REQUEST

Current Zoning: R-6MF(CD) (multi-family residential, conditional)
Proposed Zoning: R-22MF(CD) (multi-family residential, conditional)

Approximately 14.8 acres located on the west side of Krefeld Drive, east of Monroe Road, and west of East Independence Boulevard

The petition proposes to develop the site with up to 320 multi-family dwelling units on the vacant site in southeast Charlotte, east of McAlpine Creek Park.

**RZ-1.0**

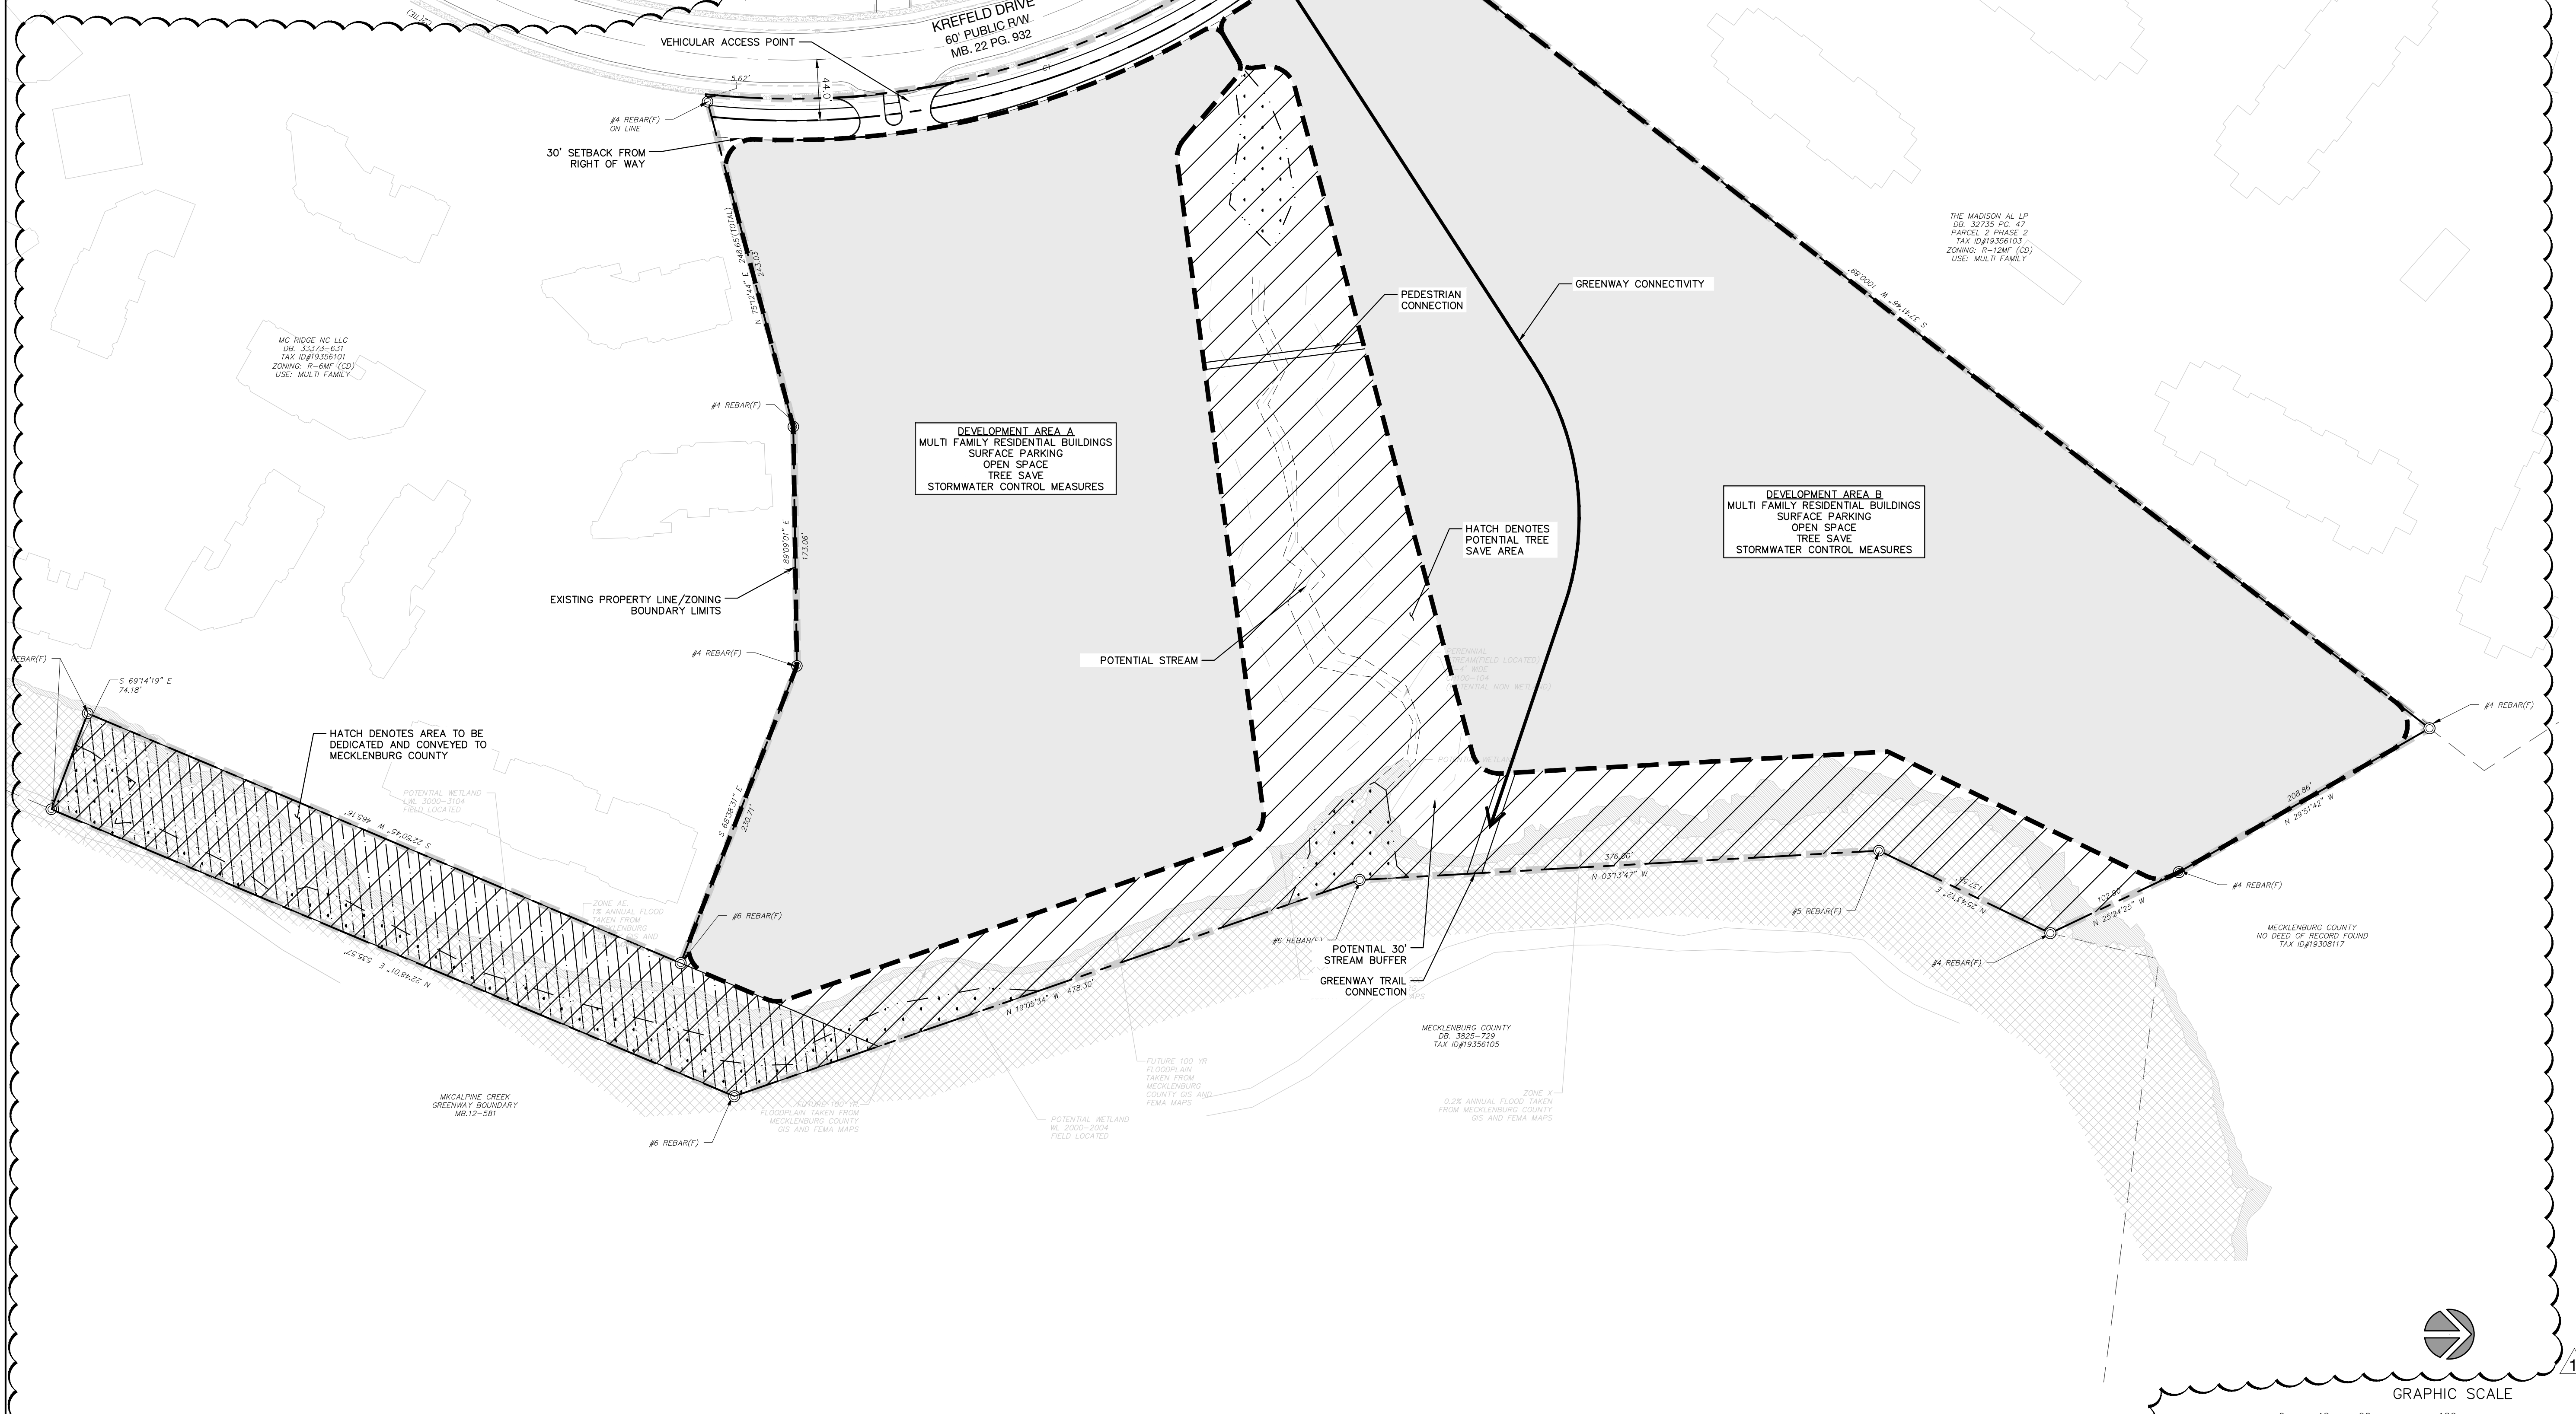
2. Clarify intent of trail connection shown on plan and noted in Park Dedication Note 1. The way the note reads now it sounds as if only residents of the proposed project would be able to use the connection. Planning staff requests the note be revised to include a public access easement so other residents along Krefeld could access the park. Addressed, the plan clarifies that connection to the McAlpine Creek Park boundary utilizes the proposed internal sidewalk network not intended for public use/access. Planning staff rescinded the request for public access after communication with Mecklenburg Parks and Recreation and confirming that the connection would be similar to the connections at the adjacent existing multi-family developments.

3. Adjust north arrow to match site orientation. Addressed.
4. Amend Streetscape, Buffers, Yards, and Landscaping Note 4 to state the "Solid waste facilities will be provided as required by Solid Waste, exact locations to be determined during permitting." Addressed.

5. Amend the Development Data table to include the minimum % of open space required. Addressed
